**Albuquerque Studios Master Plan
Development**

Traffic Impact Study

HT#R16DA3006A
Received
1/12/2022

January 4, 2022

Figure 17 summarizes the recommendations for traffic control and lane configurations for the Implementation (Buildout) Year.

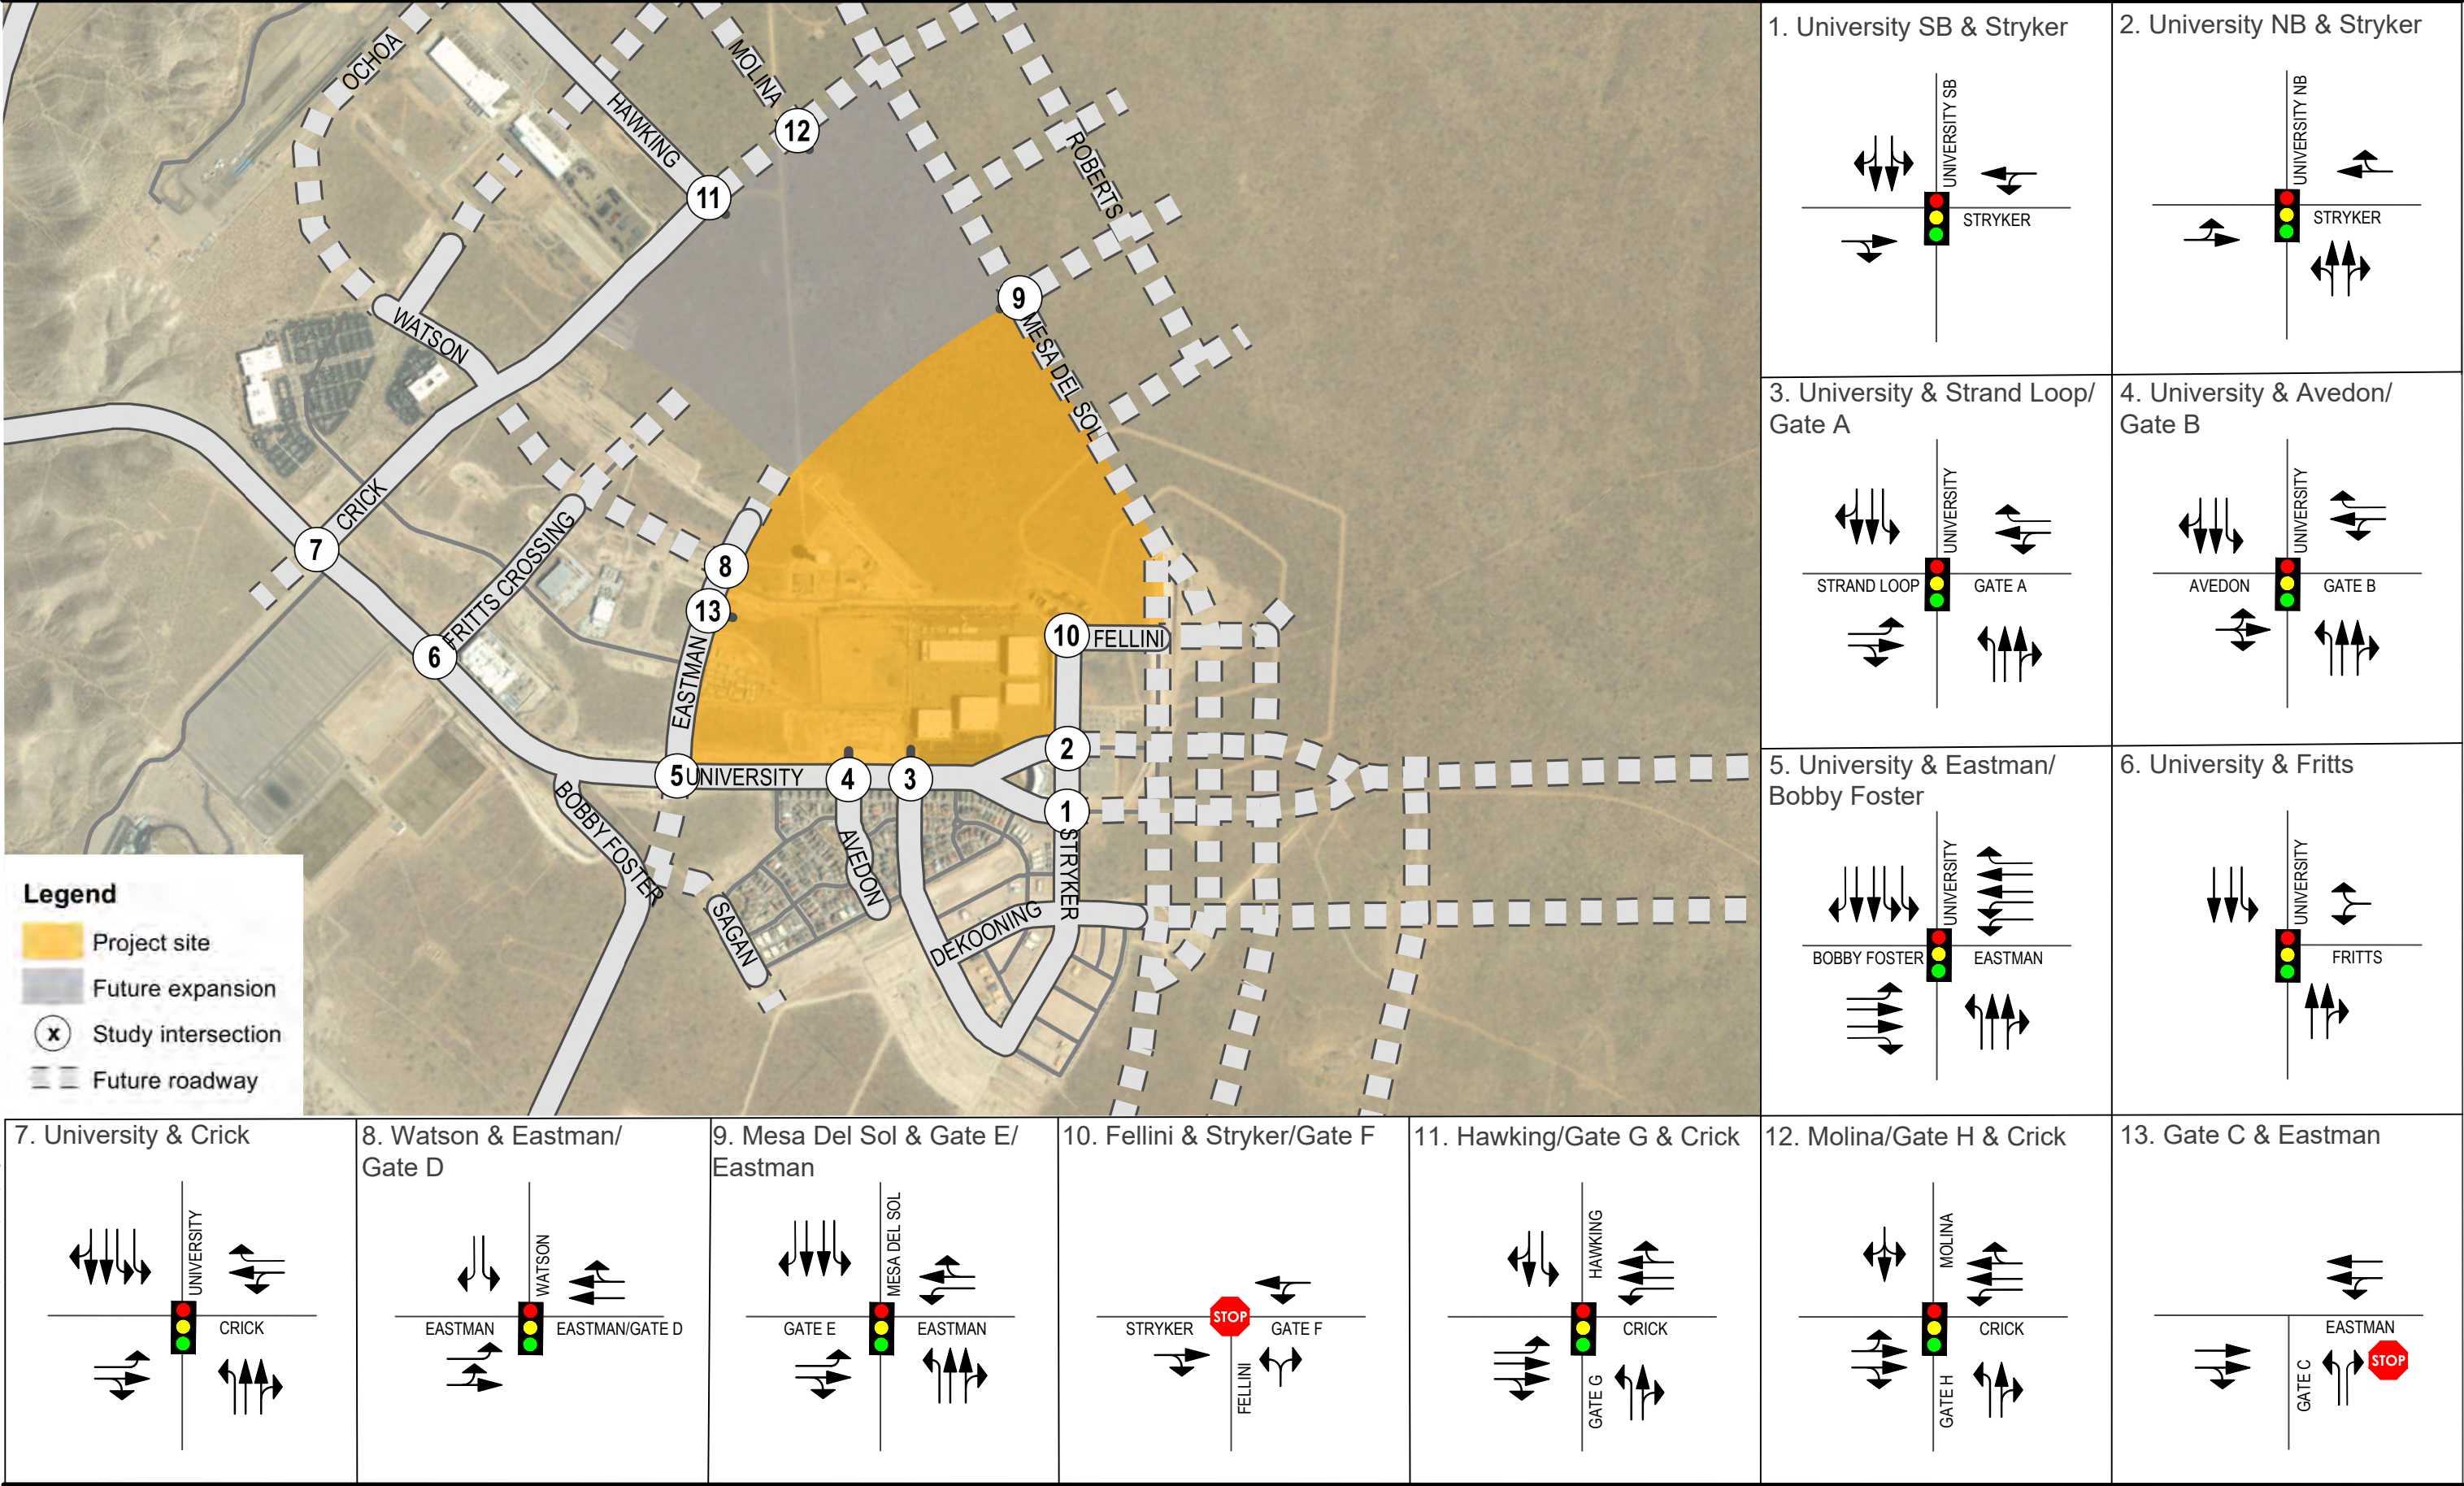
Intersection 1: Stryker west side of University;

- University SB left – (Netflix Traffic) This is a one-way SB route so there is no center lane. A left/thru with just striping is proposed. This lane (SB) to be striped and signed as a combination through/left-turn lane

Intersection 2: Stryker east side of University

- Stryker EB right – not feasible because University is one-way north bound at that intersection
- Install/Add a Stryker WB right turn lane –
- Construct sidewalk on Stryker along the south side only. The sidewalk width and buffer to be as per the Mesa del Sol typical section for this street classification

Intersection 5: University Boulevard and Eastman Drive/Bobby Foster

- The Mesa del Sol Master developer along with the City has decided that this intersection is to be traffic signal controlled. The intersections should be designed as the ultimate intersection geometric configuration to include a minimum all required travel lanes, dual left-turn lanes, one right turn lane, adequate median width for pedestrian waiting, bicycle facilities, sidewalks and landscape buffers. Provide evidence with conceptual drawings that the intersection can be constructed at this location.

Intersection 9: Eastman/Mesa del Sol Blvd.

- Mesa del Sol NB left - (Netflix traffic) to be added/constructed in the median
- Eastman EB right (Gate E) - (Netflix traffic) - Not applicable. Eastman R/W has been vacated and is now a private drive coming out of Netflix private property therefore public infrastructure improvements are not required.
